**CITY OF ALBUQUERQUE
PLANNING DEPARTMENT
October 20, 2010
DRB Comments**

PROJECT # 1003926

APPLICATION # 10-70291

RE: Lots 10 & 11, Block 15, Perea Addition

LOTS 10 & 11  
BLOCK 15  
PEREA ADDITION  
(B2-45)

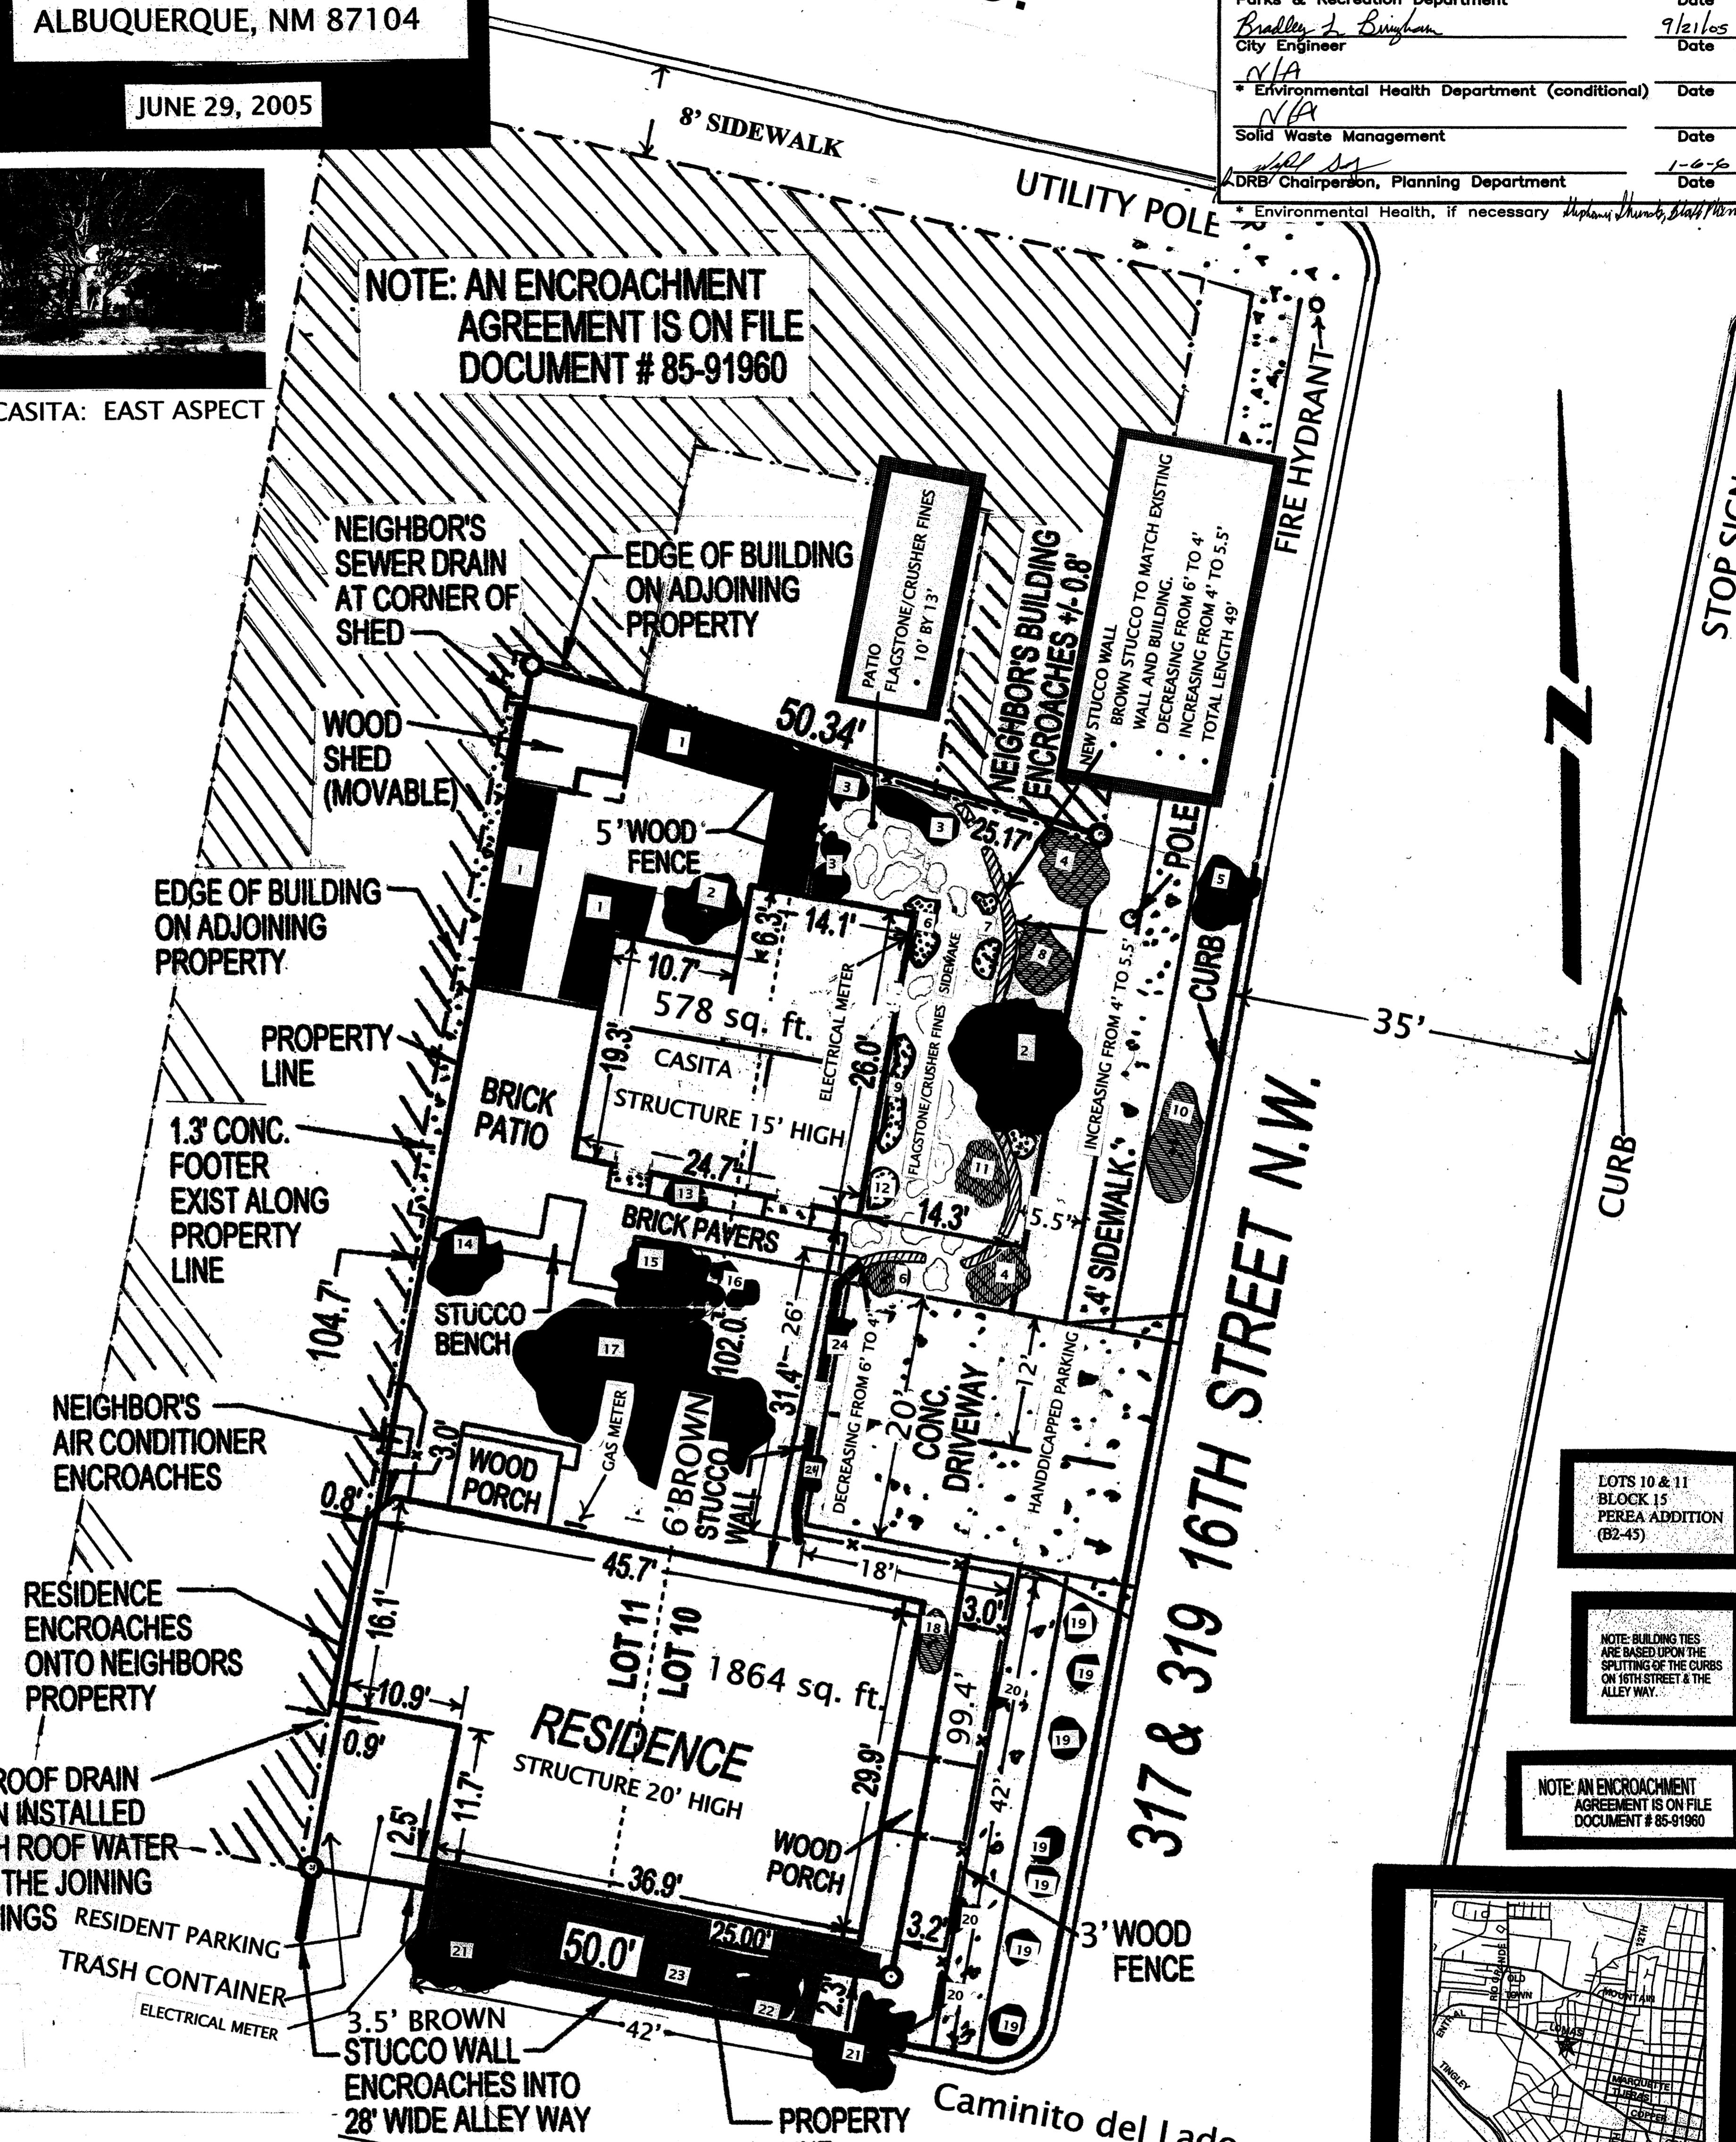
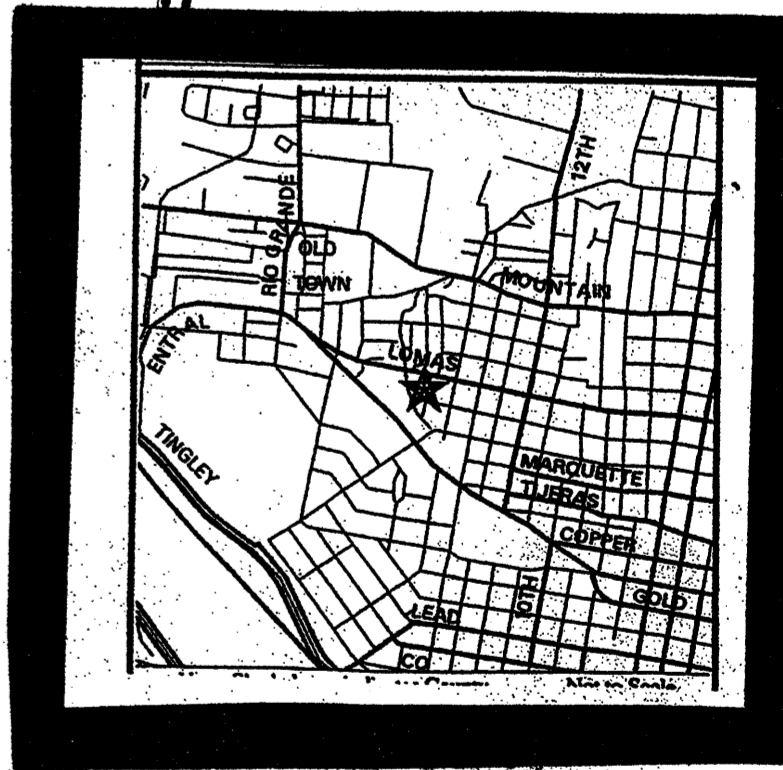
The proposed lot line must conform to building code requirements – proposed lot line should be on the south side of brick pavers walkway to the casita; use easements may still be required for casita patio area that would be on the other (south) lot.

Encroachments need to be corrected – buildings need to be modified or adjoining lots need to be included in plat.
